CRITERIUM[®] ENGINEERS

January 8, 2016

Re: 28 Harvey Street, Portland, ME
Limited Structural Evaluation - Phase 1 Dormer Design

Sketch Title 28 HAVELY ST. PORTLAND, ME  
EXISTING SKETCHES  
Project \_\_\_\_\_  
Drawn by JCN  
Checked by \_\_\_\_\_

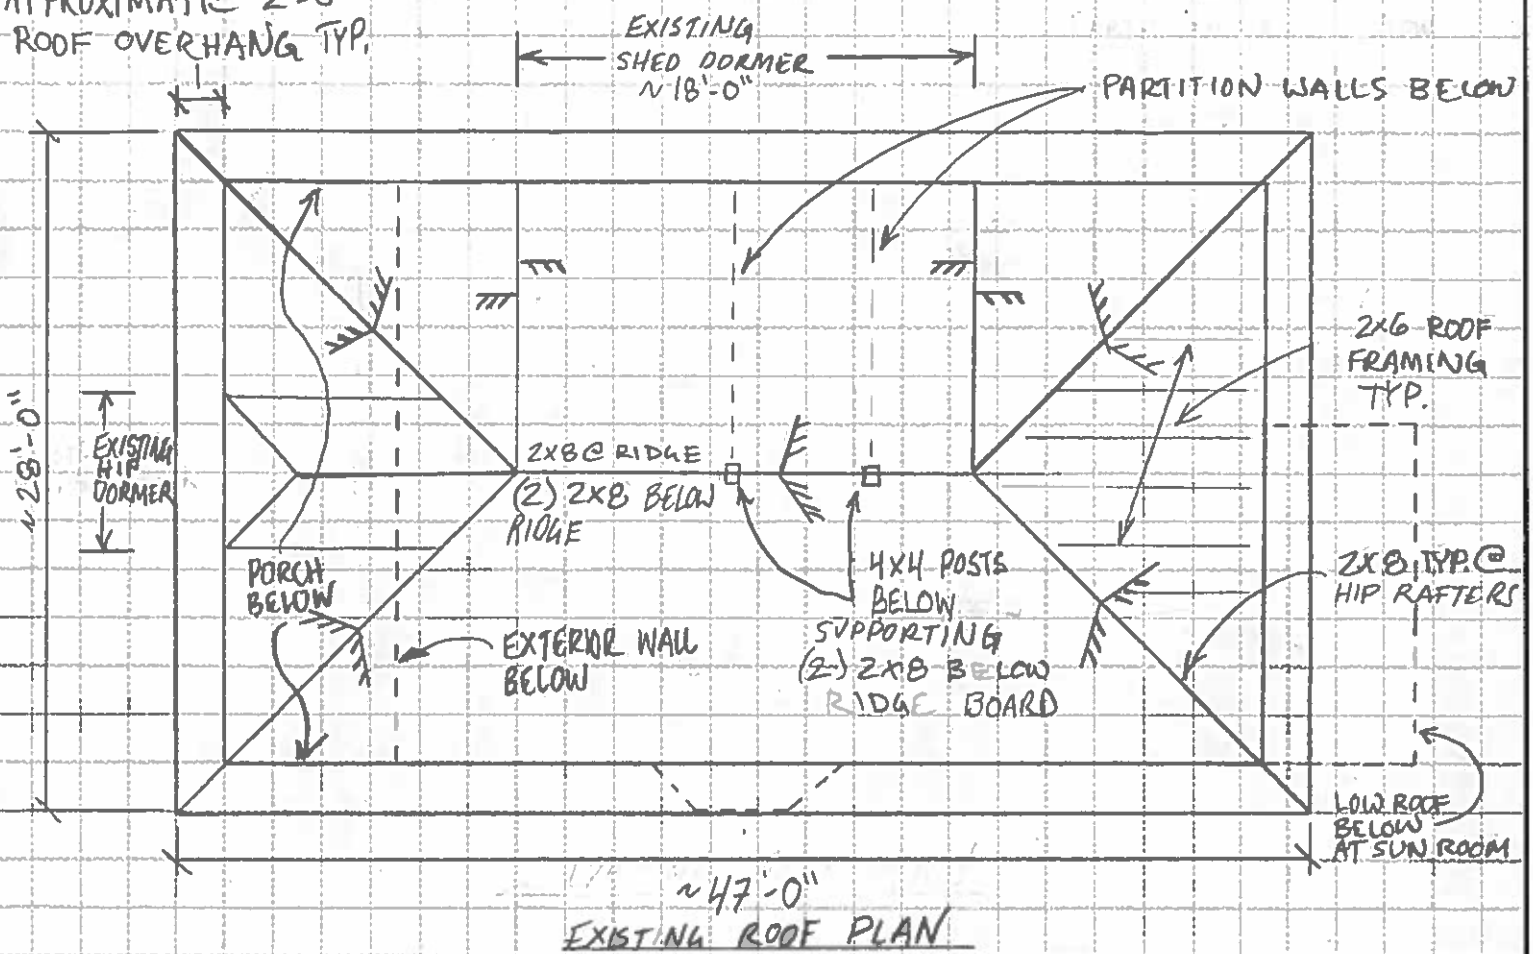
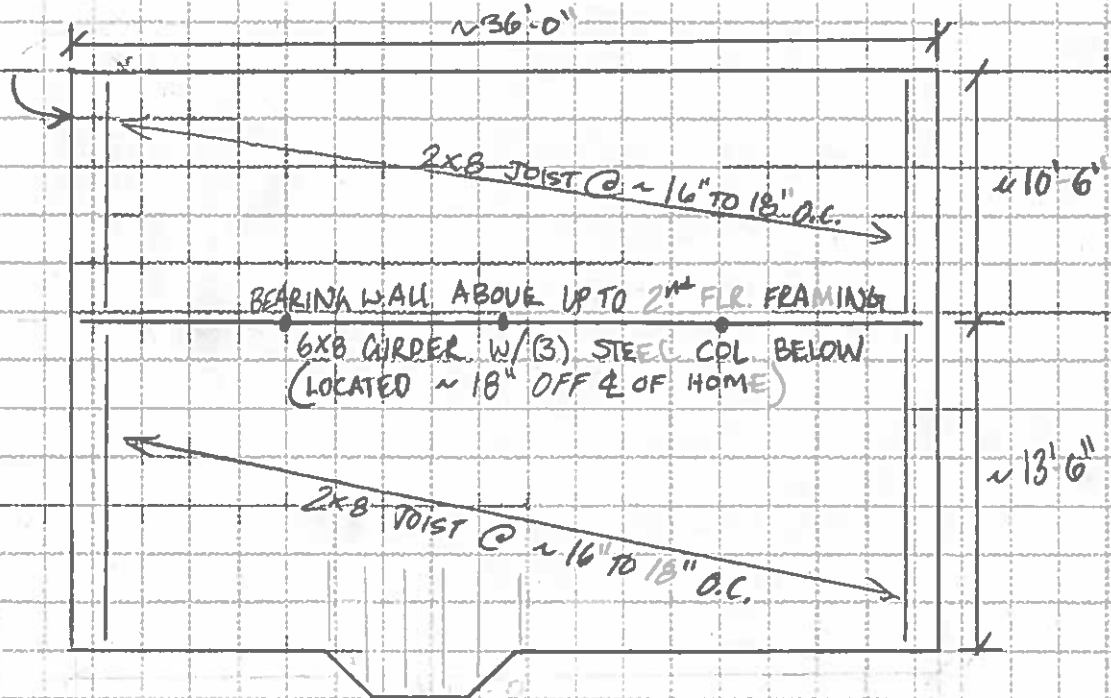
The roof is framed as a hip roof with two existing dormers. A small hip dormer extends off the left roof and a large shed dormer extends off the rear roof (photos above). Roof rafters generally consist of 2x6 lumber at 24-inches on center. The framing at the rear dormer was inaccessible, but appeared to be 2x8 dimensional lumber at 12" on center (photos below).

The hip rafters and ridge are 2x8 lumber. A double 2x8 is installed below the ridge and appears to be supported by two 4x4 posts (photos below). The support below the 4x4's was concealed.

Based on information provided by the owner, Bobby Soucy, the new shed dormer will be approximately 12-feet wide and the roof would run from the existing ridge-line to the exterior wall with a 3/12 pitch. The existing second floor partition wall below the ridge-line would be removed. Then, new walls on each side of the ridge would be added to create a second floor hallway as well as an additional bedroom at the added dormer.

To accomplish the layout described by the homeowner, we recommend designing the east added hallway wall as a bearing wall that would align vertically with the first floor bearing wall below. This wall would extend to the underside of the roof rafters at the existing rear dormer. These rafters would then cantilever over the added bearing wall and support the ridge. The ridge (and cantilevered rafters) would inturn support one side of the roof rafters at the added dormer. A bearing wall would also be added along the exterior wall to support the other end of the roof rafters at the added dormer. Walls at the ends of the existing and new dormers (the walls running perpendicular to the roof ridge) would serve to provide lateral resistance for the roof.
